Re: Gibson Shops - Wienerschnitzel
400 Gibson
Traffic Circulation Layout
Architect's Stamp 03-14-18 (L15-D049)

Based upon the information provided in your submittal received 03-14-18, the above referenced plan cannot be approved for Building Permit until the following comments are addressed:

Logan Patz
Traffic Engineer, Planning Department
Development Review Services

TCL-1.0

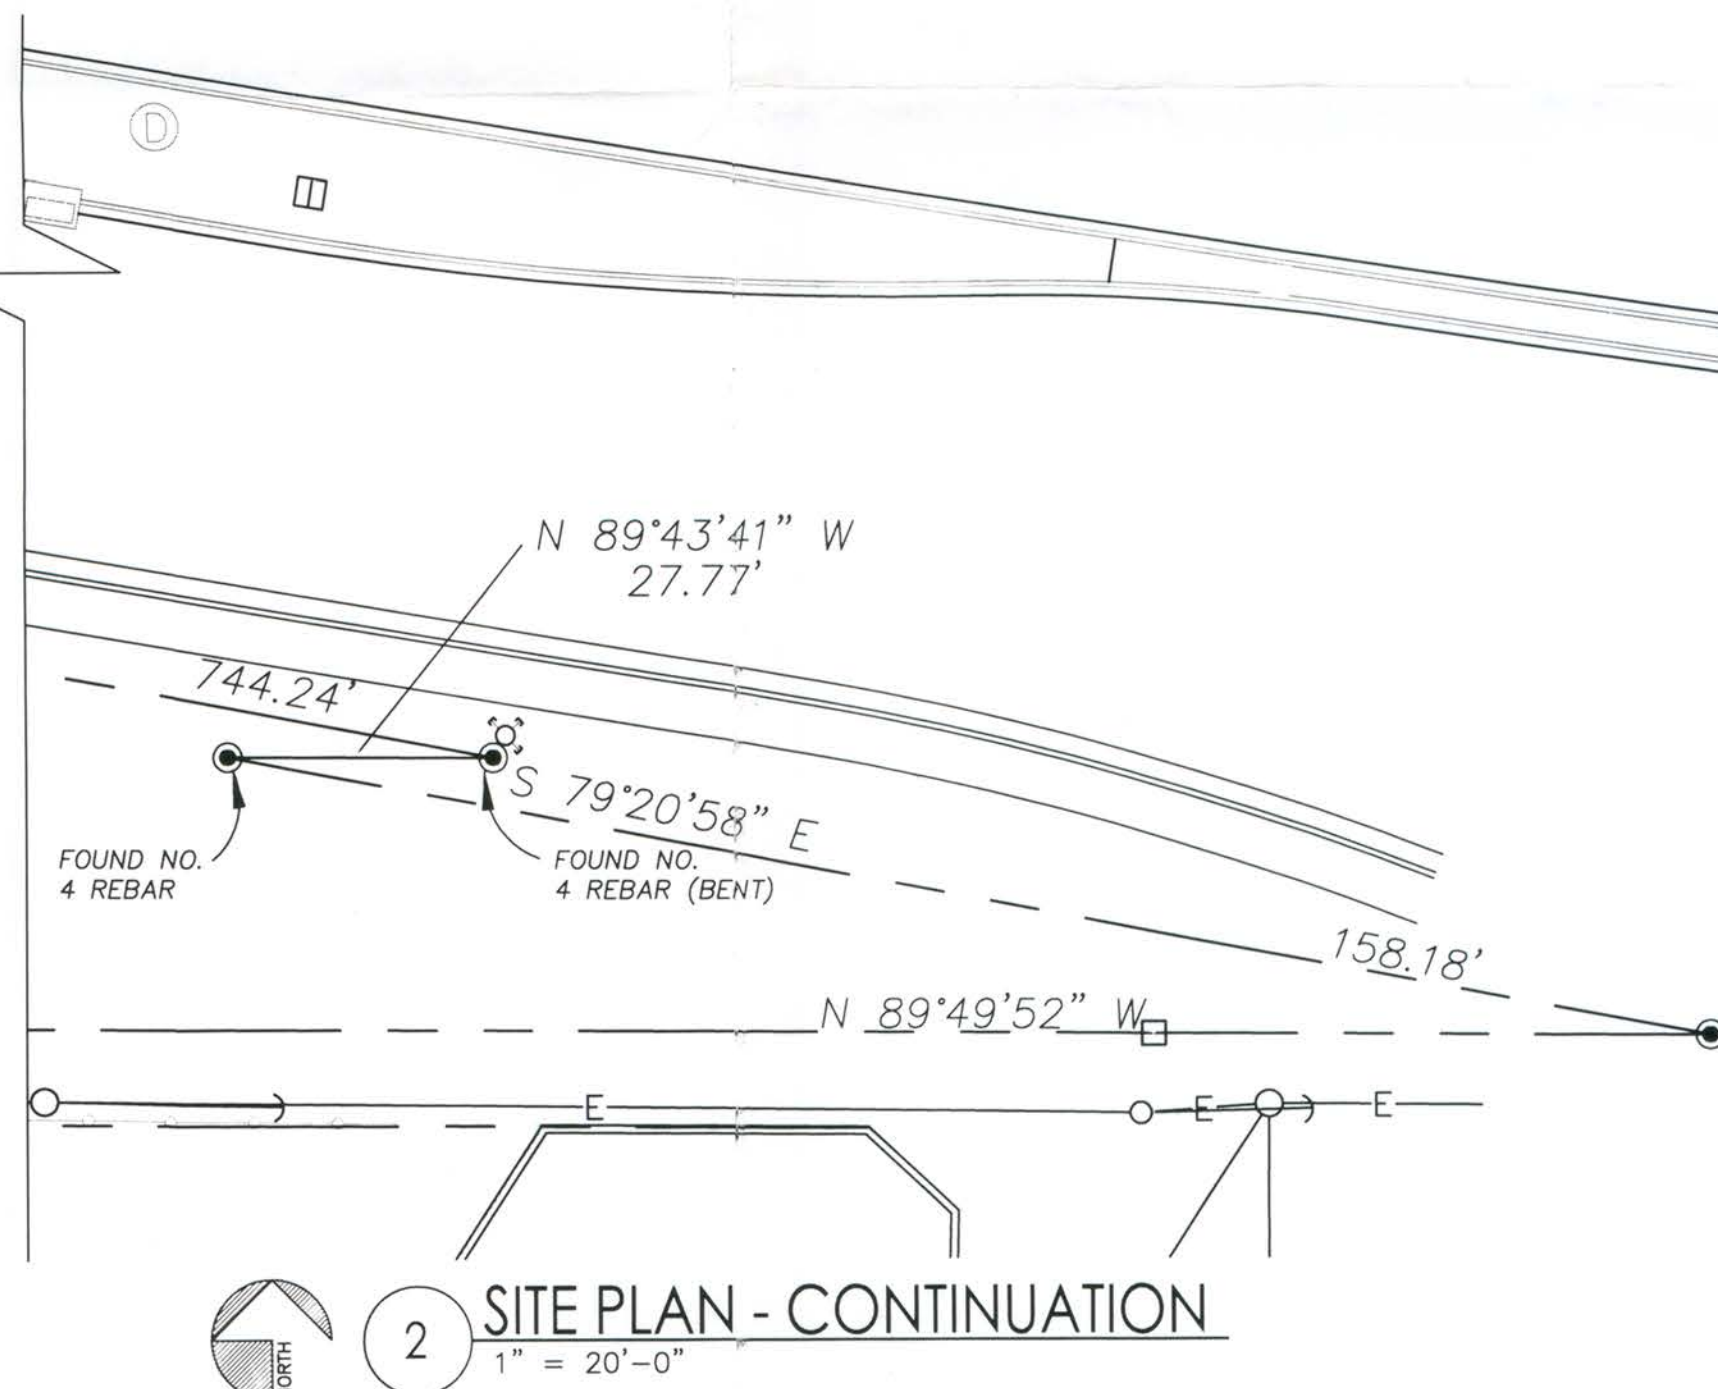
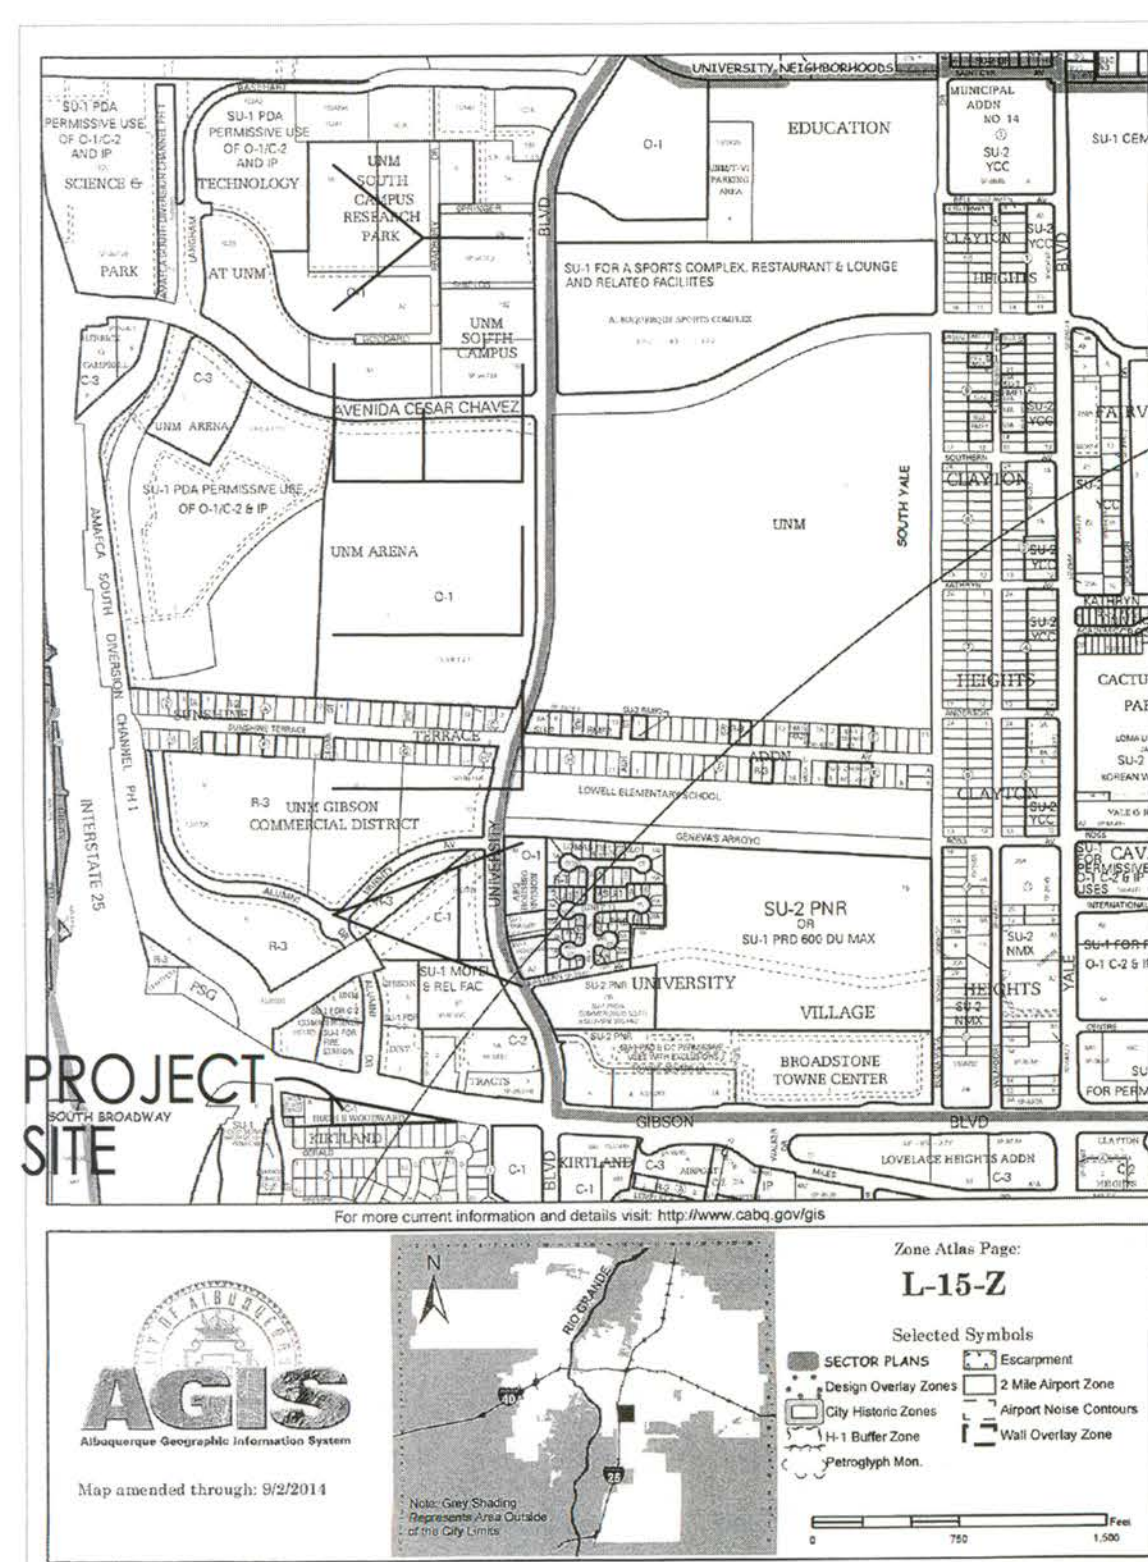
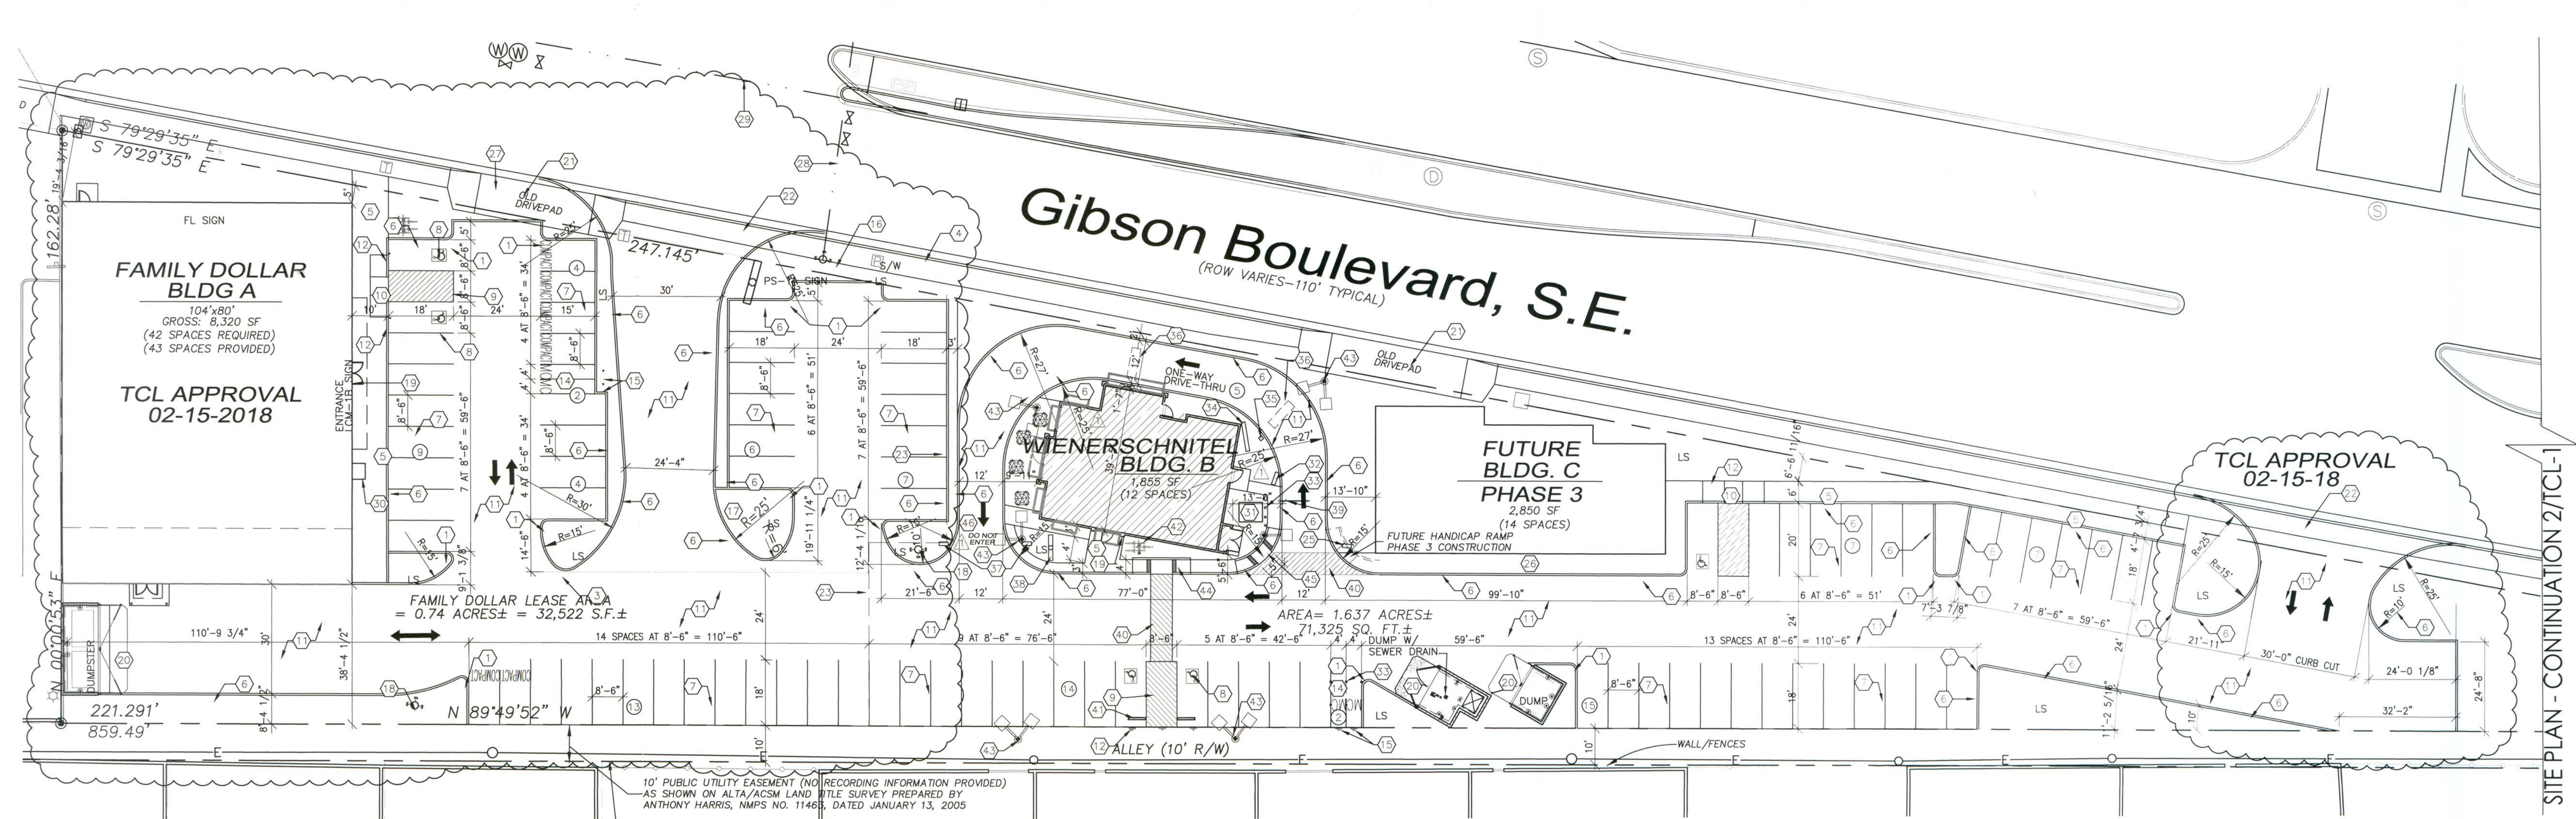
1. One-way vehicular paths require pavement directional signage and a posted **"Do Not Enter"** sign at the point of egress. Please show detail and location of posted signs.
2. The minimum drive through lane width is 12 feet with a 25 foot minimum radius (inside edge) for all turns. (A 15 foot radius can be used with an increase in lane width to 14 feet). Please dimension all lane widths and radii.
3. Please add a note on the plan stating "All improvements located in the Right of Way must be included on the work order."
